26 June 2019

**Re: Application by Cleve Hill Solar Park Ltd for an Order Granting Development Consent for the Cleve Hill Solar - Response to Examining Authority's first written questions and requests for information (ExQ2).**

Kent County Council (KCC) provides the following response to the first written questions published by the Planning Inspectorate on 7 June 2019.

**Public Rights of Way
and NMU Survey Locations**
Figure 14.3

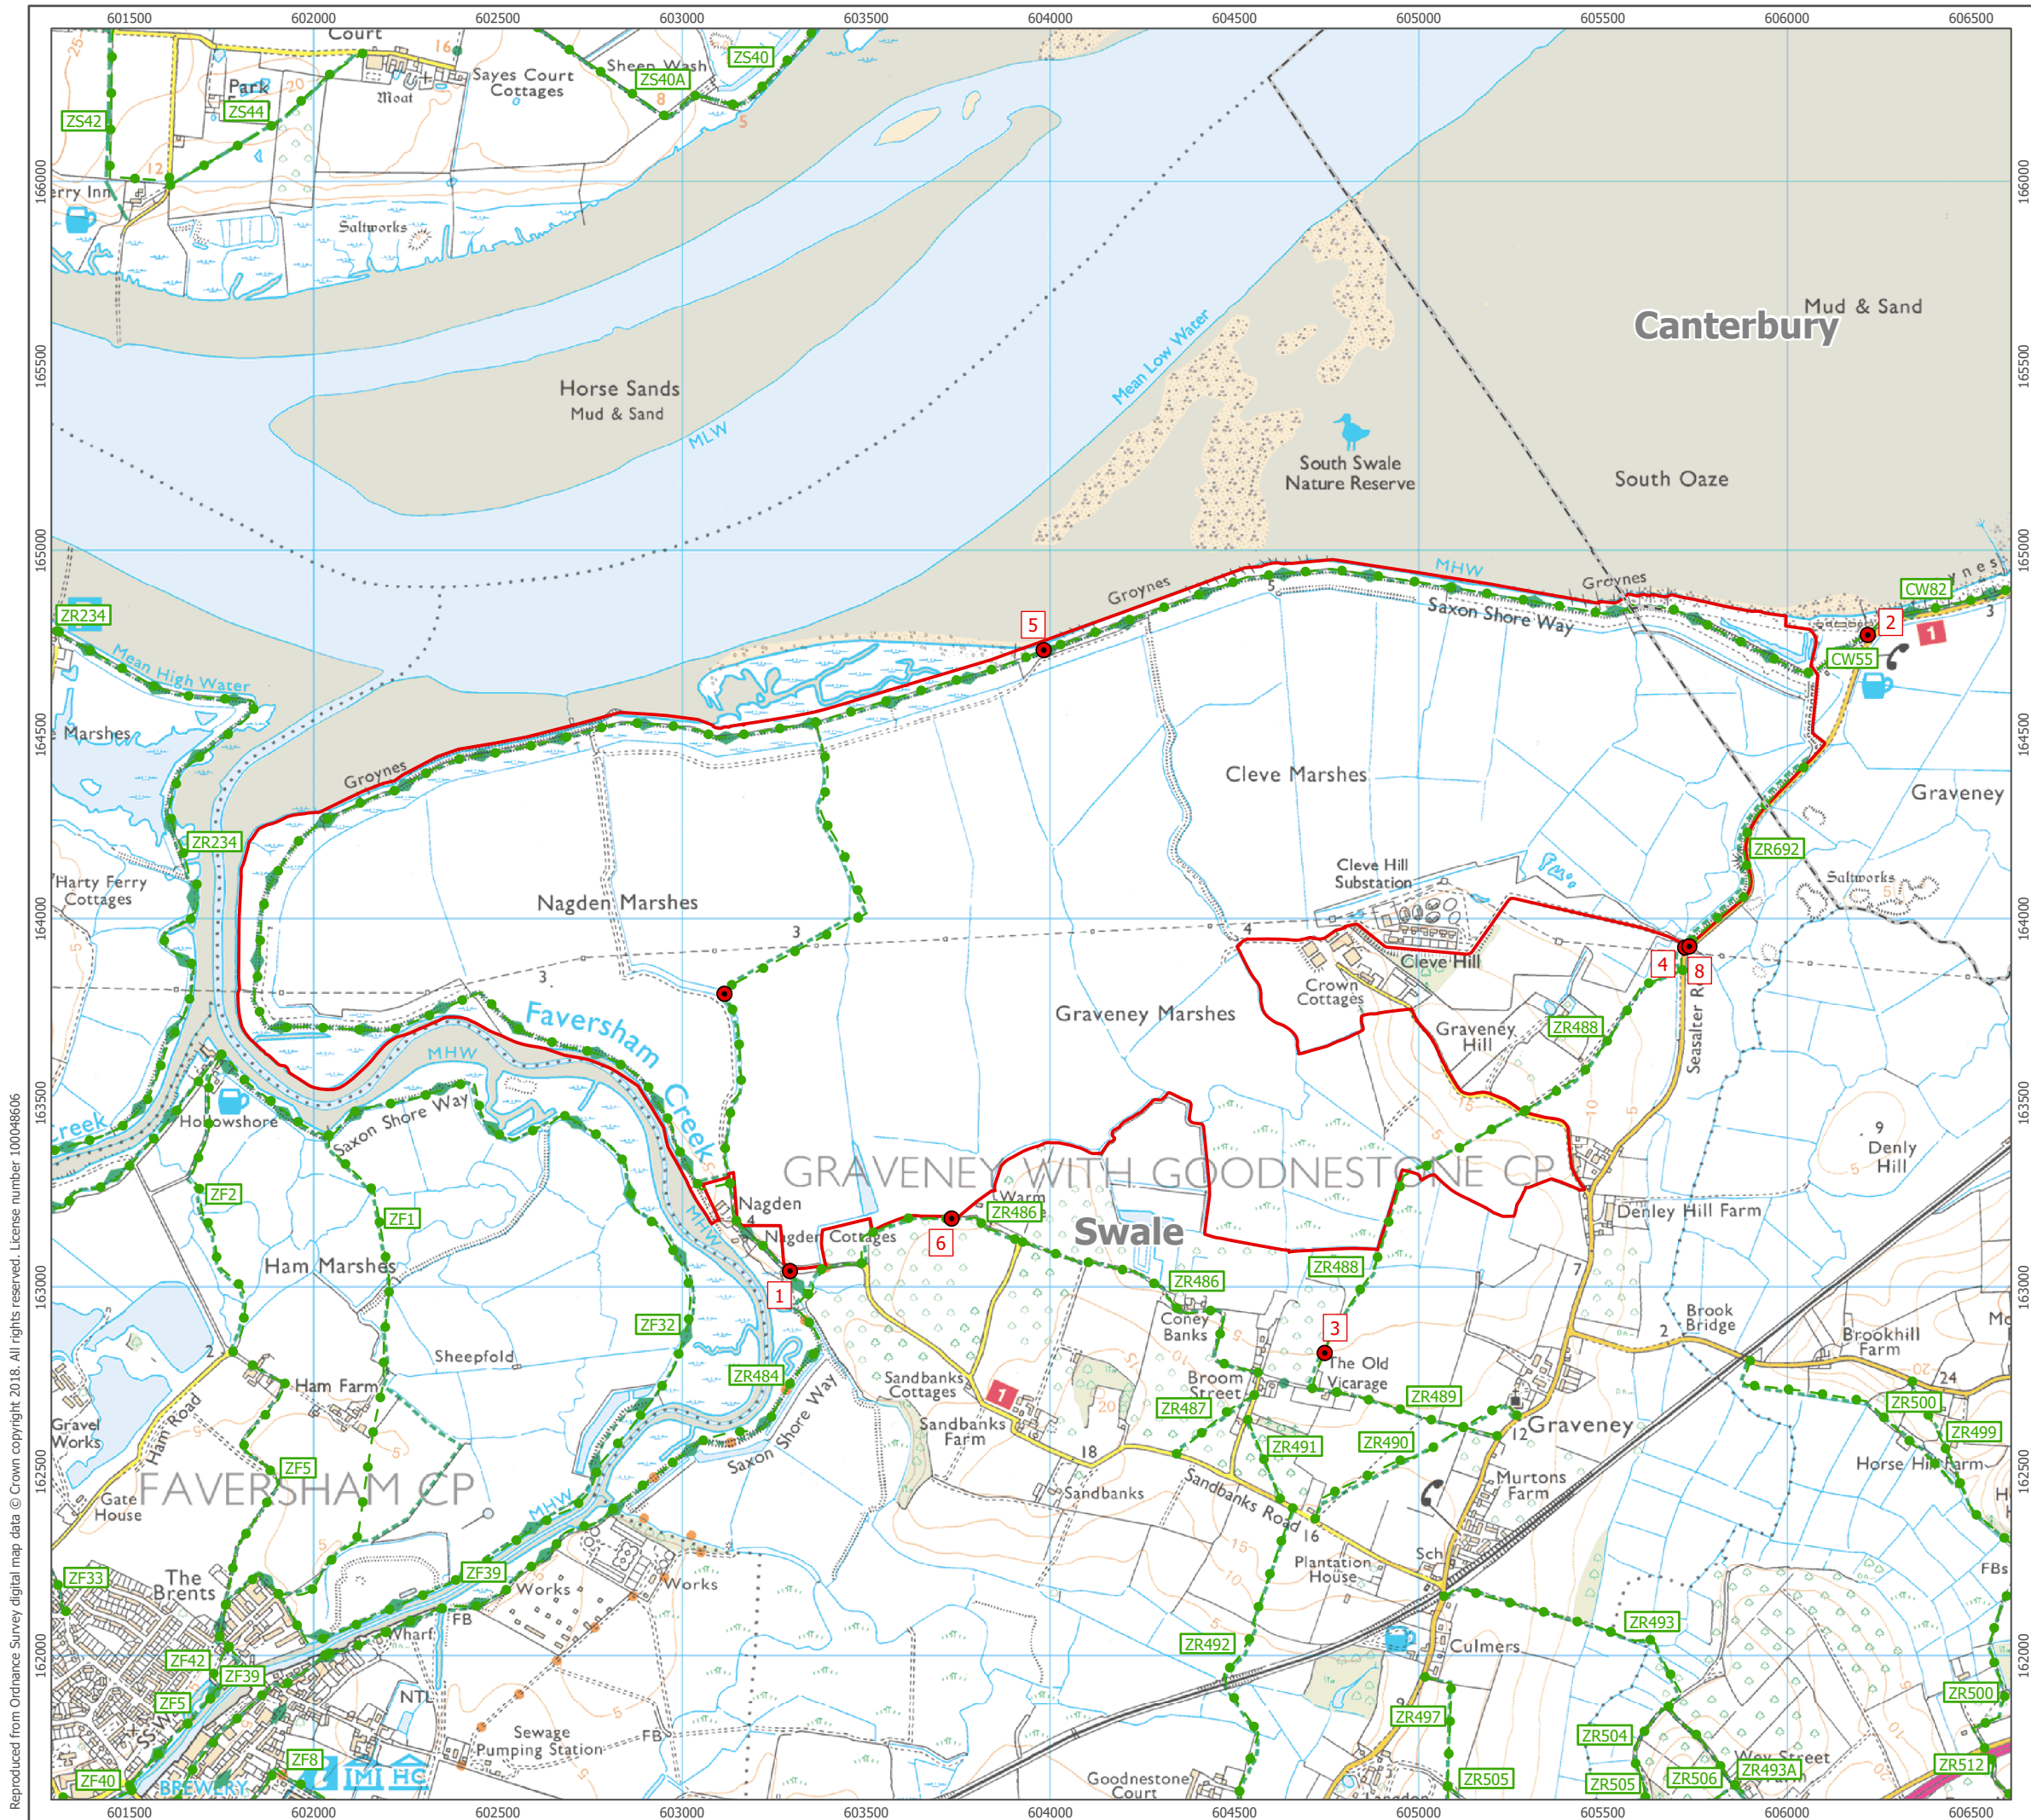
The County Council, as Local Highway Authority responsible for the Public Rights of Way (PRoW) network, is content with the locations presented in the LVIA, as photomontages for locations 2, 3 and 22 show the scale and visual effects of the proposed development. However, considering the length of Footpath ZR484 around the boundary of the site, additional photomontages along this PRoW (between viewpoints 1-2 and 3-4) would be useful as they would have helped to illustrate the cumulative effects of the development on this path.

With regards to the findings of the LVIA, the assessment considers the potential effects of the development at various locations on the PRow network. However, KCC does not agree that the LVIA considers the cumulative impact of the development when walking the entire length of these routes. In particular, Public Footpath ZR484 (the Saxon Shore Way), which passes around the boundary of the site and Public Footpath ZF485, which passes directly through the Core Landscape Study area.

The LVIA acknowledges that there would be major/moderate visual effects (which are considered to be significant) on PRow ZR484, ZR485 and ZR488 during the construction, operational and decommissioning phases of the project (paragraphs 329, 331, 335). While KCC agrees that these effects are likely to be significant, the LVIA concludes that the effects would be acceptable following embedded mitigation. The County Council considers that the proposed screening (vegetation planting) would not significantly reduce the severity of the visual effects. This can be seen with the year 10 photomontages for viewpoints 2, 3 and 22, as the planting does not appear to have any positive effects on the views.
